**Consultation Response from KC,
Trees**
2026/92432 adj to, 46, The Fairway, Fixby, Huddersfield, HD2 2HU
Formation of a vehicular access and relocation of existing gates
Date Responded: 5th October 2026
Responding Officer: AR
Responding Ref: 08/77
Arboricultural Objection - Refusal Recommended

Proposed Vehicular Access and
Highway Alterations

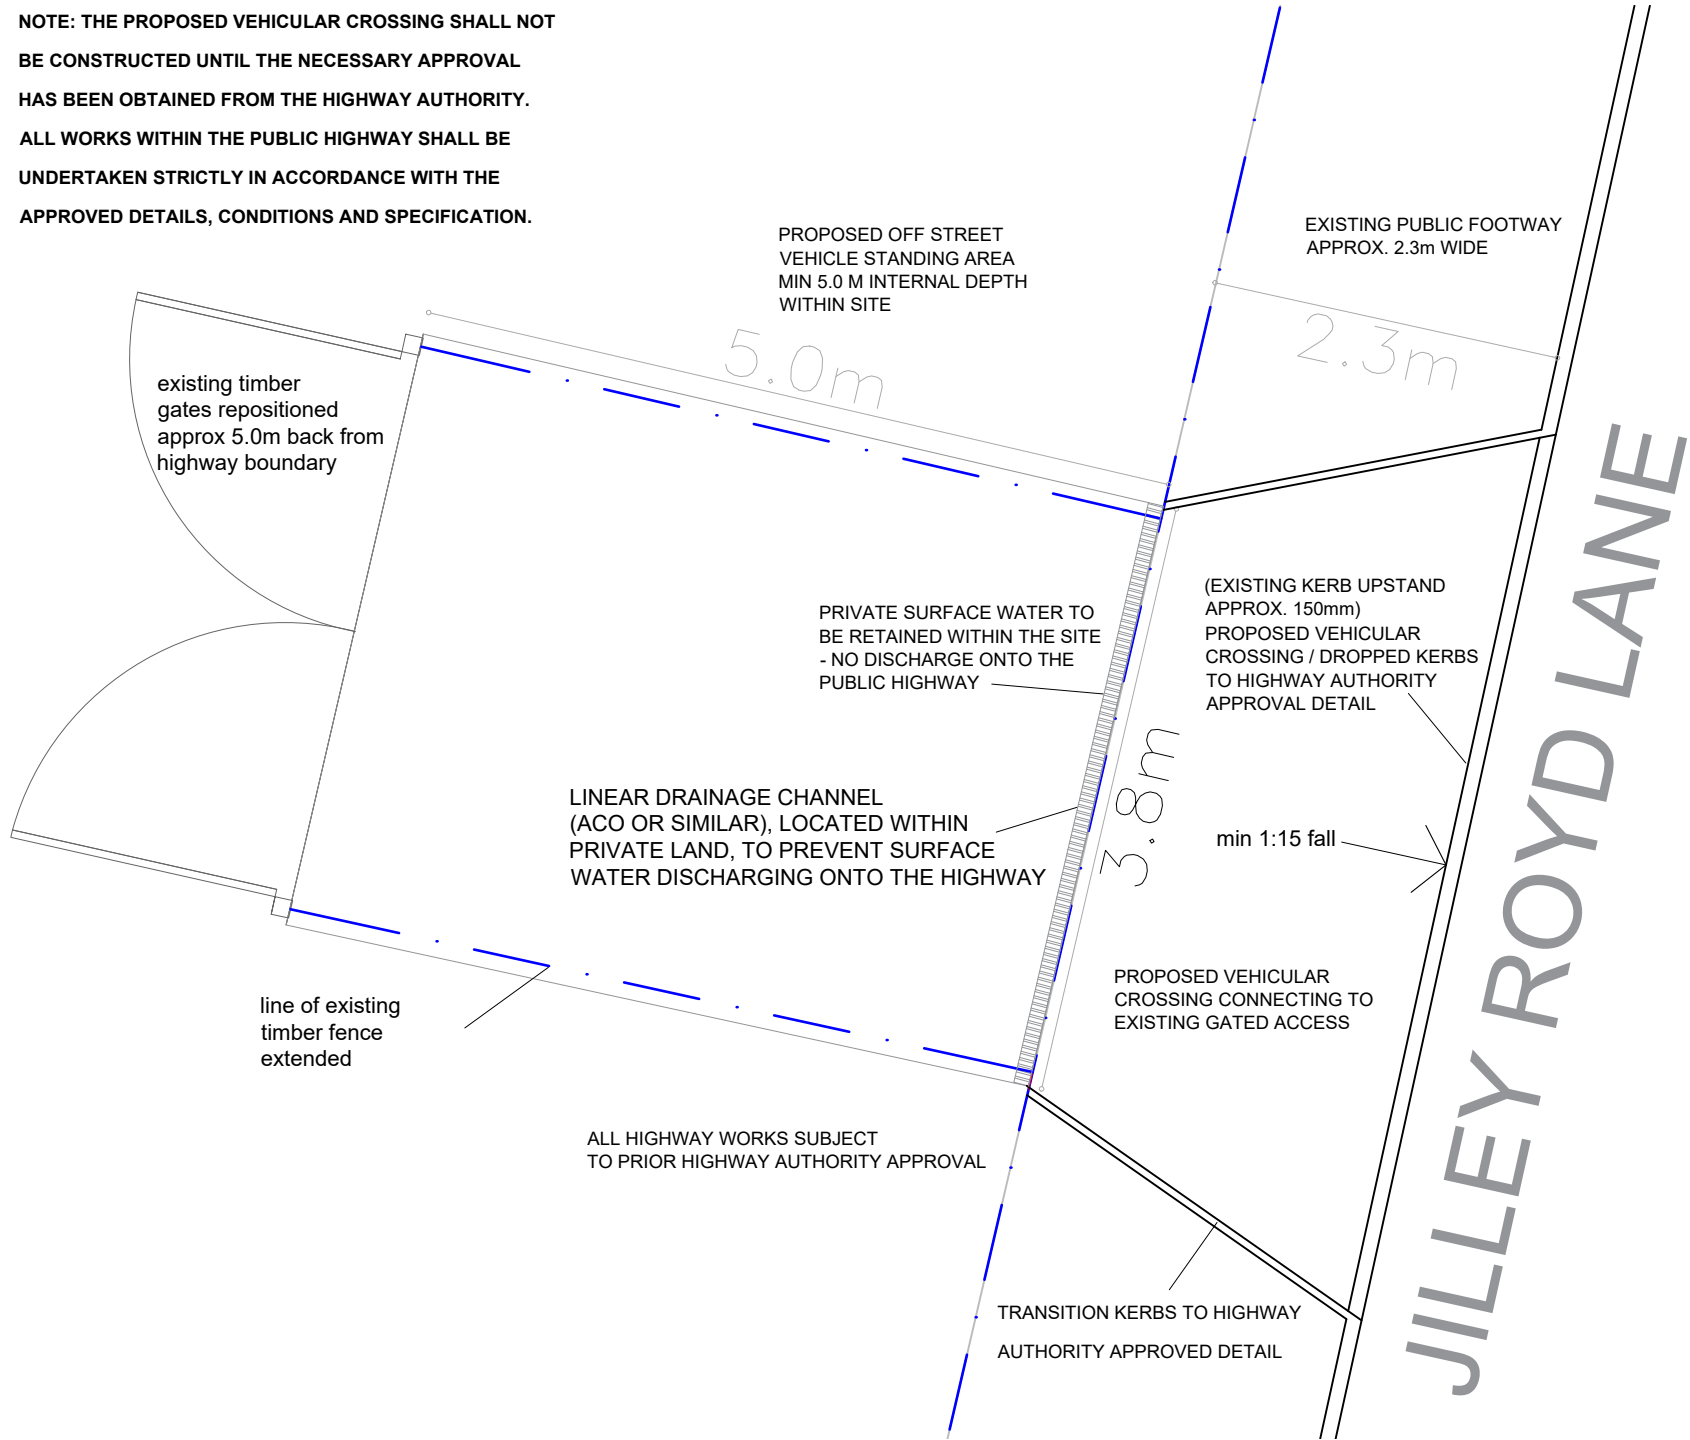
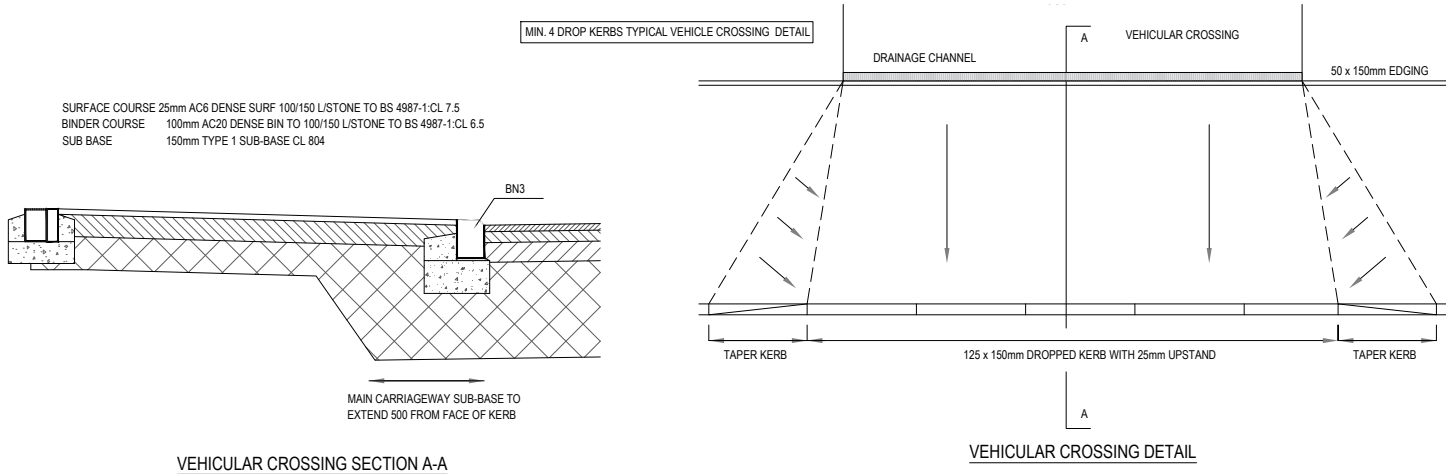
In this instance, the proposal fails to demonstrate any clear arboricultural or woodland management benefit. The Tree Team cannot identify any design solution or construction methodology associated with this proposal that would provide a positive outcome for the protected woodland without resulting in either direct or indirect impacts upon the woodland resource.

The introduction of vehicle access into the woodland environment is likely to result in ongoing ground compaction, particularly over time through repeated use and maintenance activities. Soil compaction within woodland areas can adversely affect soil structure, reduce water and oxygen availability to roots, inhibit root growth, and diminish the conditions necessary for the successful establishment of natural regeneration. Furthermore, construction activities of any nature within the woodland are likely to encroach upon areas currently available for sapling establishment and succession growth, thereby undermining the woodland's long-term sustainability.

Whilst no tree removals are currently proposed, the potential for direct and indirect impacts upon trees protected by **Woodland TPO 08/77/W1** has not been adequately assessed. Given the woodland context, it is considered inevitable that construction operations, vehicular movements, storage of materials, and associated engineering works would place pressure upon root protection areas and woodland soils. The submitted information does not demonstrate that these impacts can be avoided.
